LSC TRANSPORTATION CONSULTANTS, INC.
545 East Pikes Peak Avenue, Suite 210
Colorado Springs, CO 80903
(719) 633-2868
FAX (719) 633-5430
E-mail: lsc@lsctrans.com
Website: <http://www.lsctrans.com>

MEMORANDUM

SUBJECT: Lorson Ranch East
(PUDSP-16-003) Review 2
Response to Comments Memorandum
LSC #164360

Following are the LSC Transportation Consultants, Inc. responses to the August 15, 2017 El Paso County Planning and Community Department comments letter regarding the July 12, 2017 Updated Traffic Impact and Access Analysis by LSC.

Figure 12

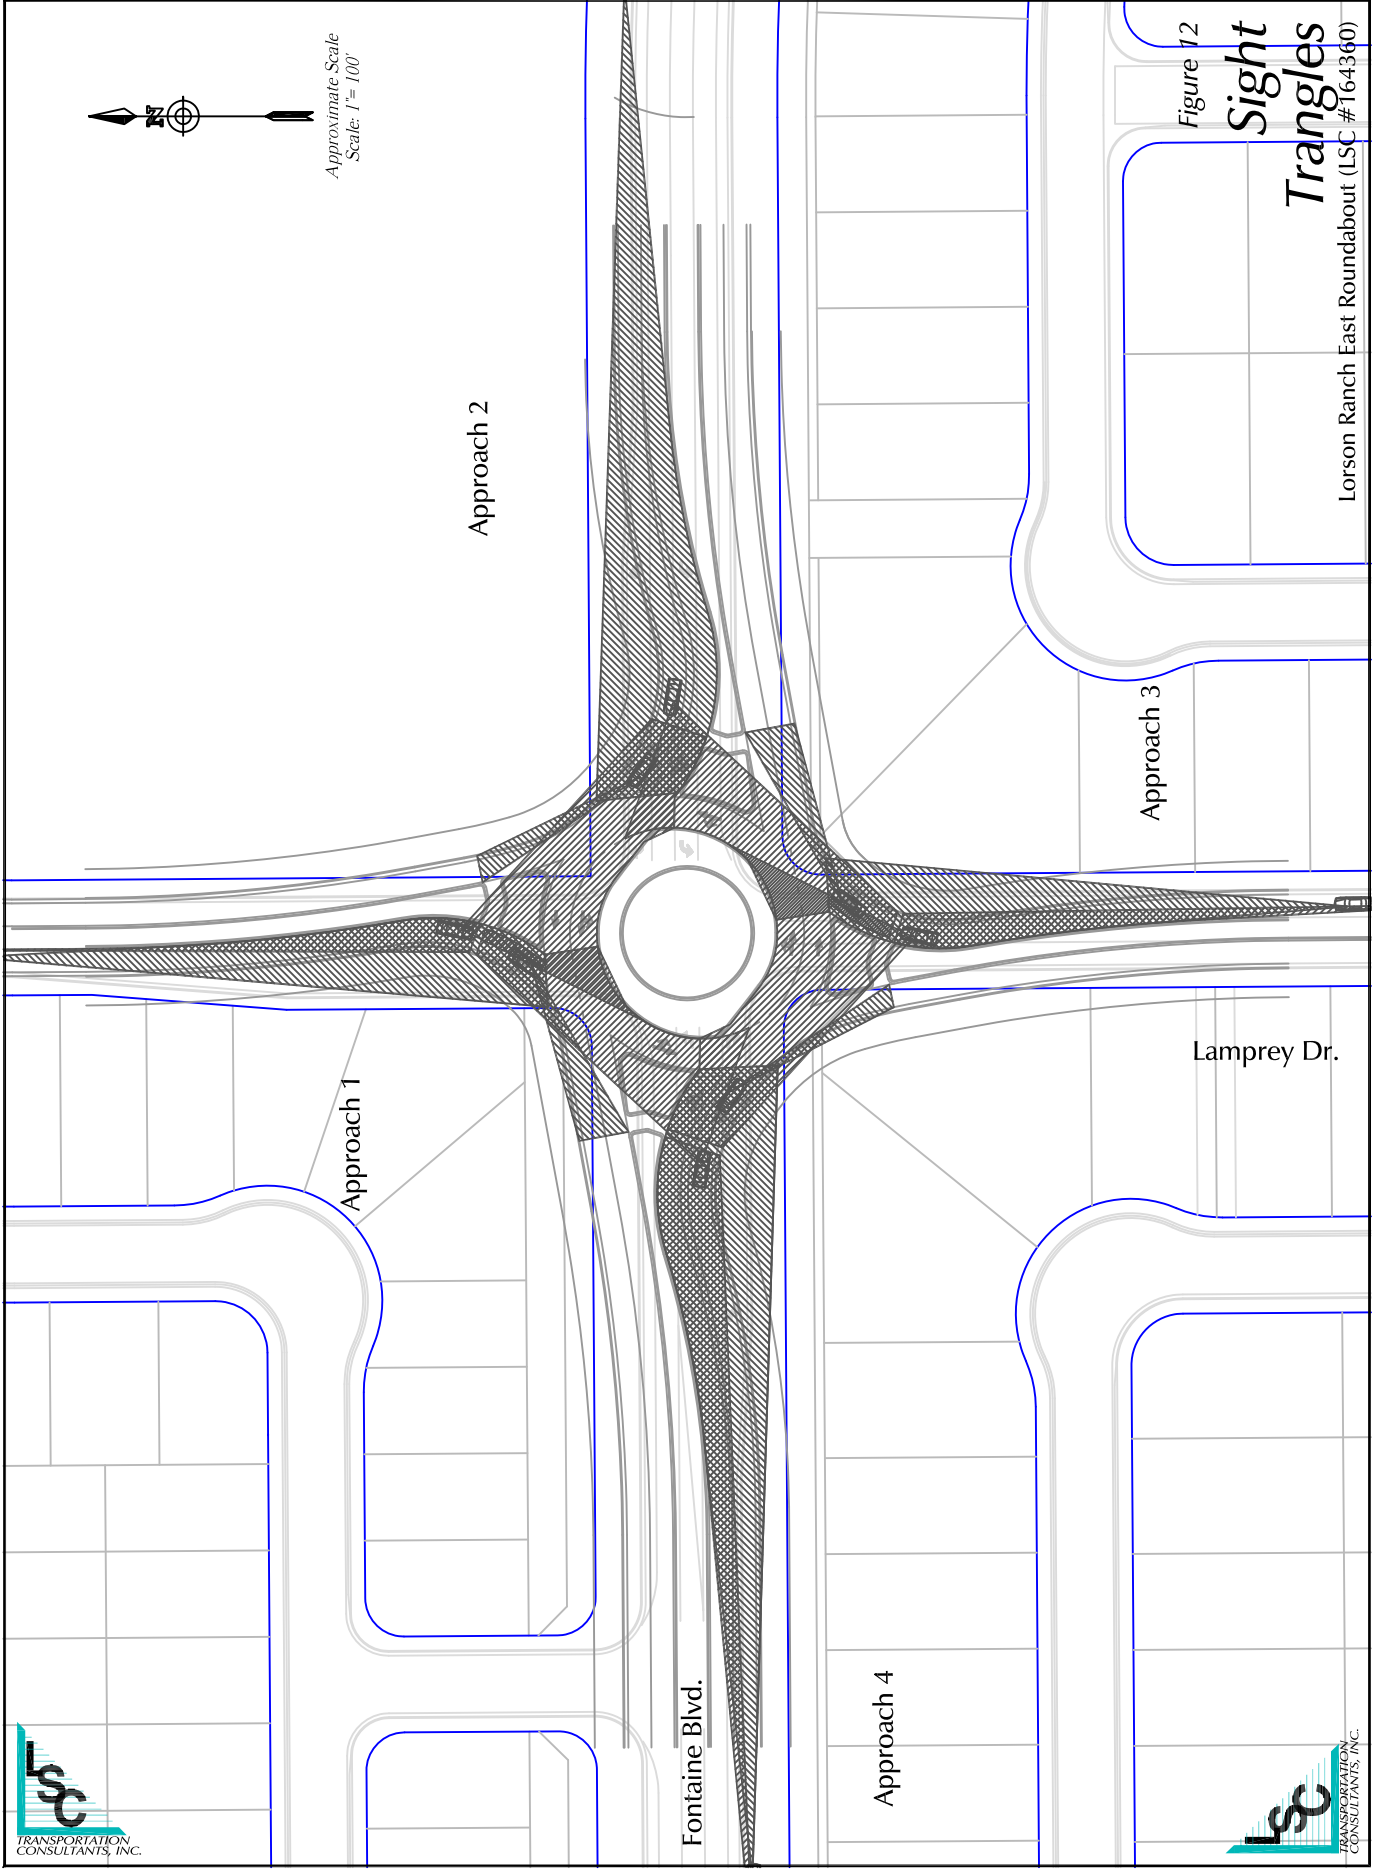
8. *Regarding the e-mailed comments dated March 17, 2017:*
*a. **It needs to be clearly documented that the roundabout is the proposed intersection at Lamprey/Fontaine. If the roundabout is the chosen option, could it not be designed to be expandable to 2-lanes when necessary along with widening of Fontaine Blvd.?***

LSC Response: The updated TIS clarifies this and clearly presents the roundabout as the proposed solution. The report also includes a roundabout design report and exhibits with the design of a future two-lane roundabout.
